Planning Officer: David Easton

Planning Application Ref: BE/40/18/PL

Location: Land West of New Barn Lane, Bersted

Description of works: New access from New Barn Lane to Land West of New Barn Lane & relocation of 5 No. existing parking spaces

Proposed Access to New Barn Lane

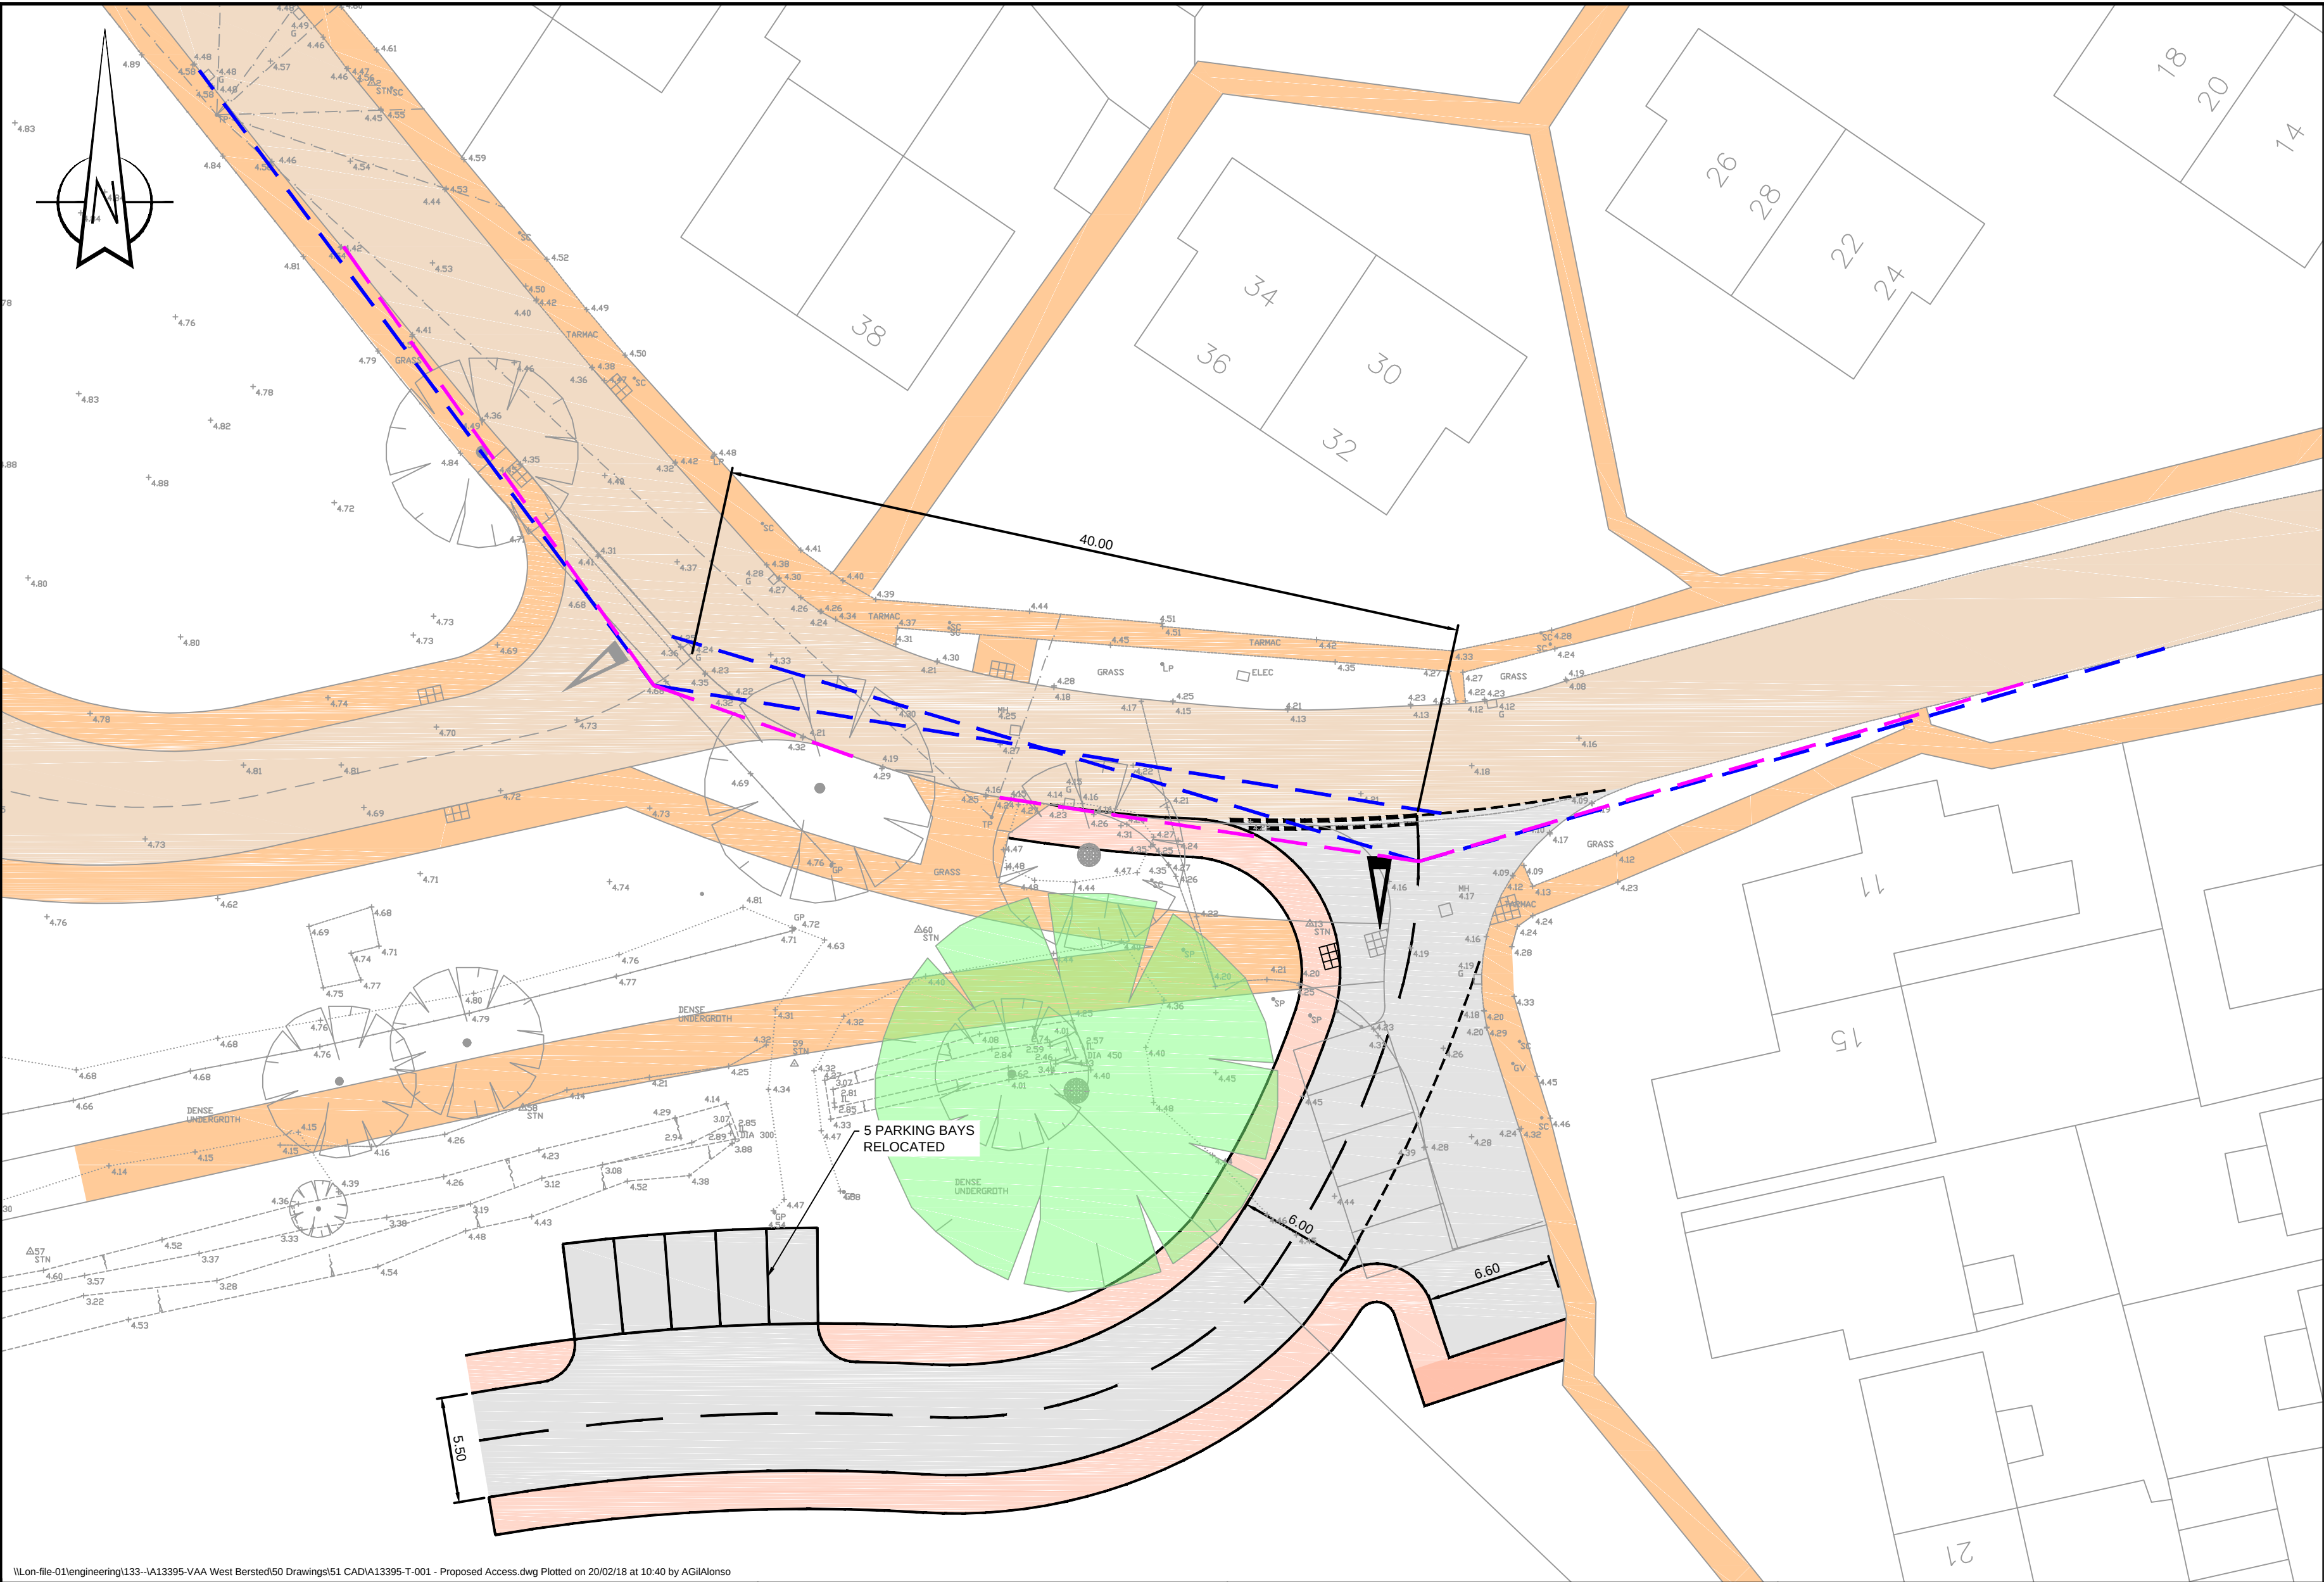
- As stated in their Proposed Access Plan Statement; the TRetP has informed the design of this new access. I have been unable to retrieve a copy of plan drawing number so have relied upon their current access plan prepared by Pell Frischmann (dwg.no.A13395-T-001) which appears to correlate with the aforementioned TRetP.

- T1 (oak) appears to be healthy, structurally sound and with good life expectancy (>40years). Despite its compact form arising from heavy low limb development and exposed location, It has landscape value and is highly visible to the public. It's attributes were previously recognised by making it the subject of an Order (TPO/BE/1/16). As development advances locally it will take on greater significance as a landmark tree of strong visual interest.

- As such, I regard this tree as being of retention Category A2 rather than the B1 rating it had been assigned, although I concur with the tree measurements recorded and associated Root Protection Area (RPA).

- The proposed relocation of parking spaces does not impact on the RPA of any significant retained tree.

- A degree of RPA incursion on the south-east aspect is proposed, not exceeding 1m intrusion and this is acceptable. This will be accurately marked out at the time of our joint pre-commencement site meeting and define part of the Construction Exclusion Zone (CEZ).
- The applicant will now need to ask their appointed Arboriculturist to submit a Tree Protection Plan that adequately protects the remaining RPA of T1-Oak throughout the duration of any development.
- Facilitation pruning will be necessary, involving the careful reduction back of branches to achieve installation of tree protective fencing at the correct position.

- The proposed access is logical and achievable without undue harm to this tree, as such I am able to lend this scheme my support. I would therefore recommend APPROVAL subject to the following conditions being applied:

1. All construction works are to be carried out in strict accordance with:-
Tree Protection Plan ref: yet to be prepared.
 2. Prior to any construction works taking place or the introduction of any machinery and plant to the site, the following issue must be resolved to our satisfaction:-

- **A PRE-COMMENCEMENT Site Meeting** is to take place between the Arun DC Tree Officer and the Arboricultural Expert representing the site owners – at this meeting protective fencing will be inspected – this will be assessed to verify it is 'Fit for Purpose' as required under British Standard 5837 and have been erected and positioned exactly as shown on the **Tree Protection Plan ref: yet to be prepared.**
